APPENDIX 1.1
KILDARE COUNTY COUNCIL REQUEST FOR FURTHER INFORMATION

Date: 04/10/2024
Pl. Ref: 24/60787

Re: Planning Reference: 24/ 60787 - Herbata Limited - PERMISSION for a Data Centre and will comprise of: The demolition of 3 no. dwelling houses, associated garages and farm outbuildings / agricultural buildings (total floor area 1,591m²); The construction of 6 no. two storey data centre buildings, each with loading bays, external plant area including electrical and mechanical plant rooms, fuel compound, sprinkler tanks and associated ancillary development; Data centre building Nos. 1, 2, 3, 4 and 6 will consist of: a data hall (24,756m², overall height 19m), an administration block (2,505m² overall height 15m) and include an external screened plant area of 18m in height and 6,164m²; Gas turbines, gas engine and battery energy storage systems will be provided within each plant area; Data centre building No. 5 will consist of: a data hall (24,756m², overall height 19m), an administration block (2,505m² overall height 15m) and include an external screened plant area of 18m in height and 6,375m² in area and includes infrastructure for district heating; Gas turbines, gas engine and

- NOTES:**
- DO NOT SCALE OFF THIS DRAWING. ALWAYS WORK TO NOTED DIMENSIONS.
 - ALL DIMENSIONS MUST BE VERIFIED ON SITE BEFORE COMMENCING WORK. DISCREPANCIES MUST BE REPORTED TO THE ENGINEER.

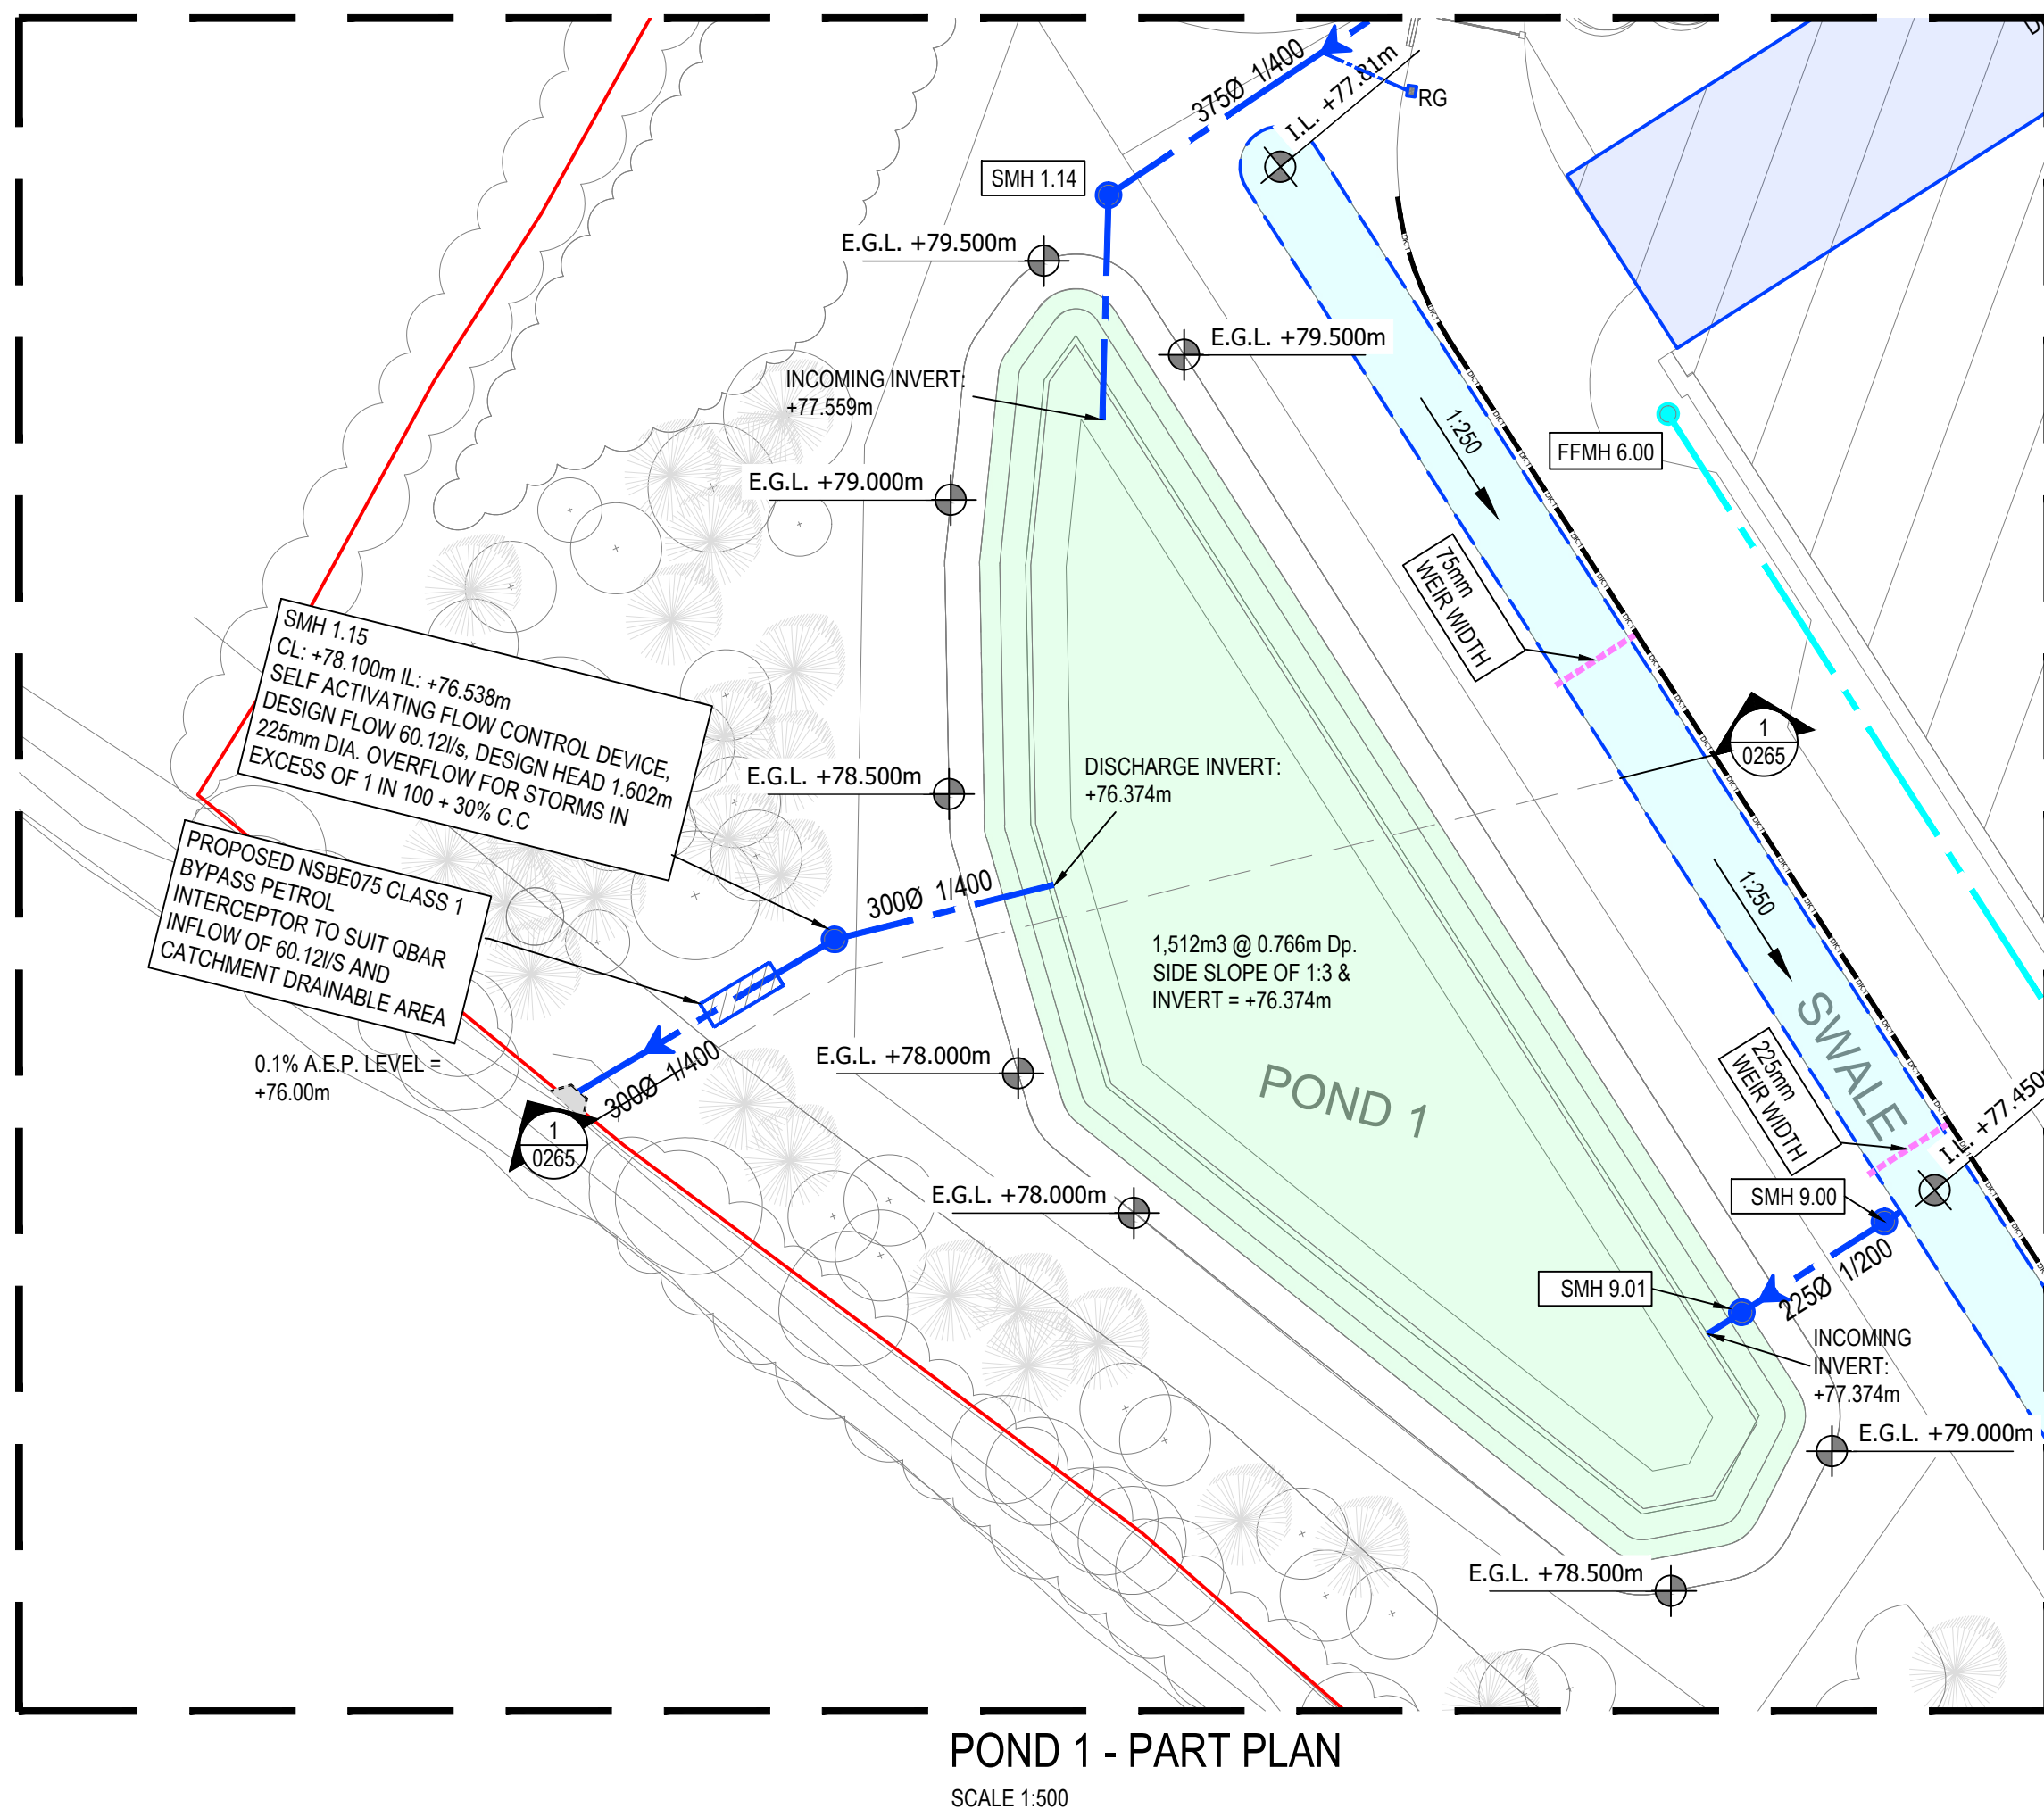
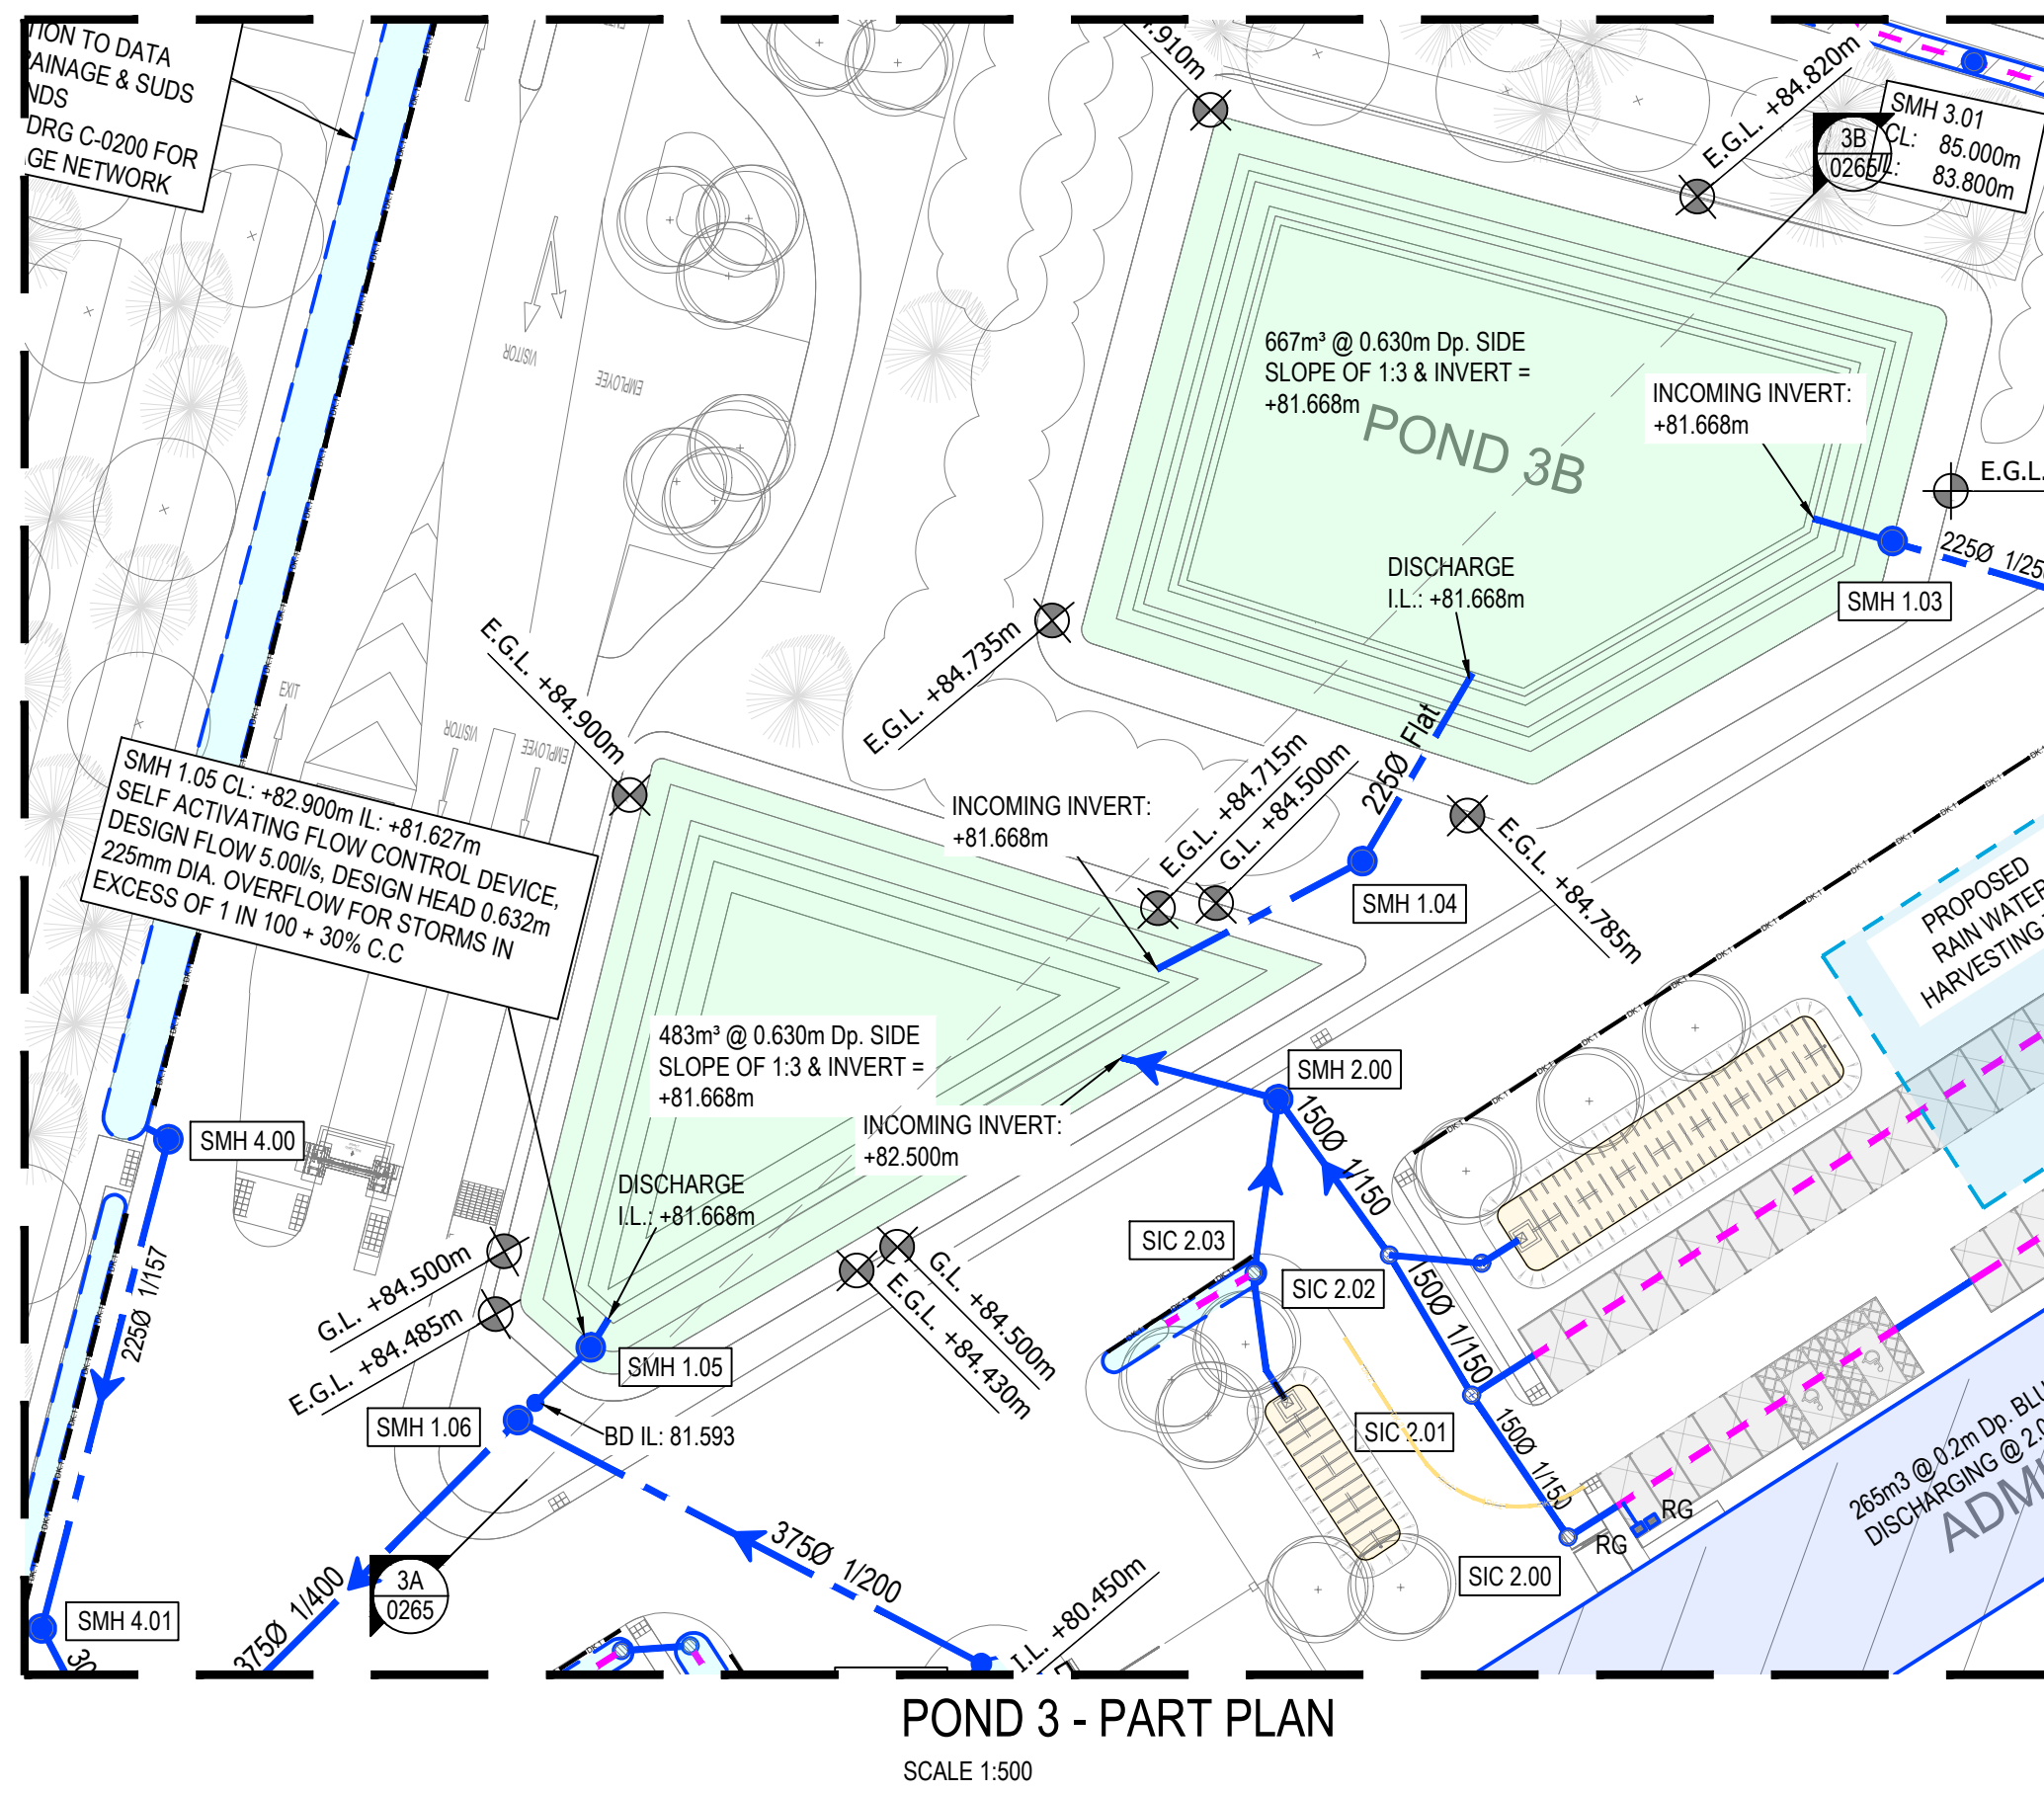
26. There is a query in relation to the figures pertaining to the estimation of the greenfield runoff rate at 6 l/s/ha. The Applicant is requested to reissue the design with a revised Qbar rate and confirm that the available attenuation storage for the site provided in the proposed ponds and basins on the site layout plan have sufficient capacity to store the increased water volumes associated with the reduced Qbar rates.

27. The Applicant is requested to reissue the Proposed SuDS Detail drawings highlighting the correct Qbar rate at each of the outfalls.
